Recommendation Report for Planning Permission for Works or Extension to a Dwelling

REF NO: AW/13/26/HH

LOCATION: 3 Grangefield Way
Aldwick
PO21 4EG

PROPOSAL: Single storey rear extension and conversion of existing detached garage with pitched roof and flat roof link to main dwelling.

Dwg. No. P-004
 Title: Proposed Elevations
 Address: 3 Grange Field Way, Bognor Regis, PO21 4EG
 Client: Cath White and Aimee Pridham
 Scale: 1:100@A3
 Stage: PLANNING
 Drawn: PS
 Date: January 2026

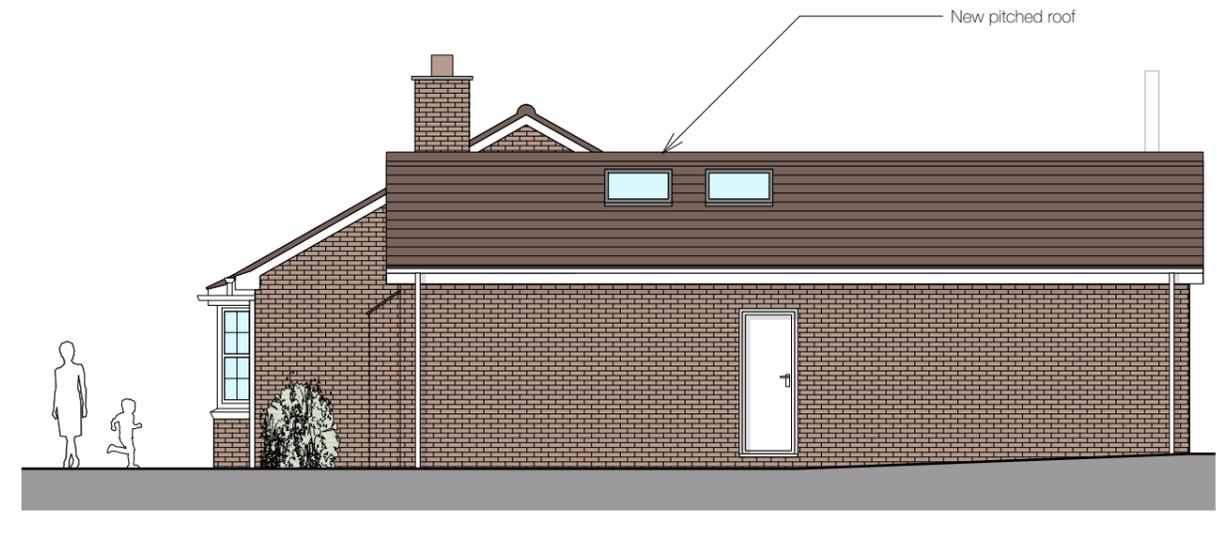
The proposed rear extension would extend approximately 23.4m across the full width of the dwelling, including the rear of the existing garage, in line with the existing flank elevations. The depth would be approximately 4.1m to the northern flank and 5.3m to the southern flank. Externally, the extension would be finished in red brick to match the existing dwelling. As part of the proposal, the existing conservatory to the rear would be removed.

The northern section of the extension would feature a pitched roof with a maximum height of approximately 4.5m and an eaves height of 2.5m. The same roof form of the same height would be replicated over the garage extension section located to the southern flank of the host dwelling, representing an increase from the existing garage flat roof height of approximately 3m. The two pitched roof sections would adjoin a central flat roofed element with a maximum height of approximately 4.3m. The pitched roof would be finished in clay tiles, matching the existing dwelling in colour and style.

The rear extension would be linked to the existing garage, infilling the area between the garage and the main dwelling. This linking section would measure approximately 1.3m in width and would have an overall depth of approximately 8.9m, aligning with the rear extension. Two new gates are proposed on either side of the existing garage to provide partial screening of the works from the street view.

The garage would retain a garage door to the front elevation, preserving the original character of the host dwelling when viewed from the street. The addition of the new gates would further assist in maintaining the property's established appearance. Two rooflights are proposed on the southern flank roof slope of the existing garage.

The rear extension would incorporate two glazed patio doors, a large window, and bi-folding doors, providing access to the private rear garden. The flat roof element would include two lantern rooflights. Two new Georgian style windows, to be obscure-glazed, are proposed within the northern (side) elevation of the existing dwelling. All fenestration is proposed as white UPVC to match the existing host dwelling.

A new log burner exhaust flue is also proposed on the rear elevation, within the northern roof slope of the extension to the rear of the existing garage. This would measure approximately 2.1m in height, comparable to the height of the existing chimney stack on the host dwelling. It would not appear unduly prominent and would not result in harm to the established character of the street scene.

The proposed depth of the rear extension would not comply with the guidance set out in the Arun Design Guide (ADG), which states that single storey rear extensions to detached dwellings should not exceed 3.3m in depth. However, the depth would be comparable to the existing conservatory. In addition, the proposal would retain a spacing of 14.6m from the rear boundary, and would preserve sufficient garden space. The extension would not be visible from the street scene and would not appear out of character with the dwelling or surrounding development. On this basis, the deviation from ADG guidance is acceptable in this instance. The use of matching materials would help to integrate the proposed extension and alterations to the garage roof with the host dwelling, and a condition is attached to this planning permission to ensure that the external materials and finishes match the host dwelling. As such, the proposal is in accordance with Arun Local Plan policy D DM4.

In relation to privacy, all proposed fenestration within the rear (east) elevation is at ground floor level. Owing to the ground floor positioning of these openings, together with the separation maintained from neighbouring properties, the proposal would not result in any overlooking to the rear. The two new side facing windows proposed within the northern (side) elevation would be obscure-glazed, further separated by the public highway. Therefore, there would be no overlooking impacts.

Rooflights are proposed on the southern roof slope of the existing garage. As the garage would not contain any loft accommodation and would incorporate a vaulted ceiling, these rooflights would not afford views toward the neighbouring property as they would be located at high level. This arrangement prevents potential overlooking of the neighbour to the south.
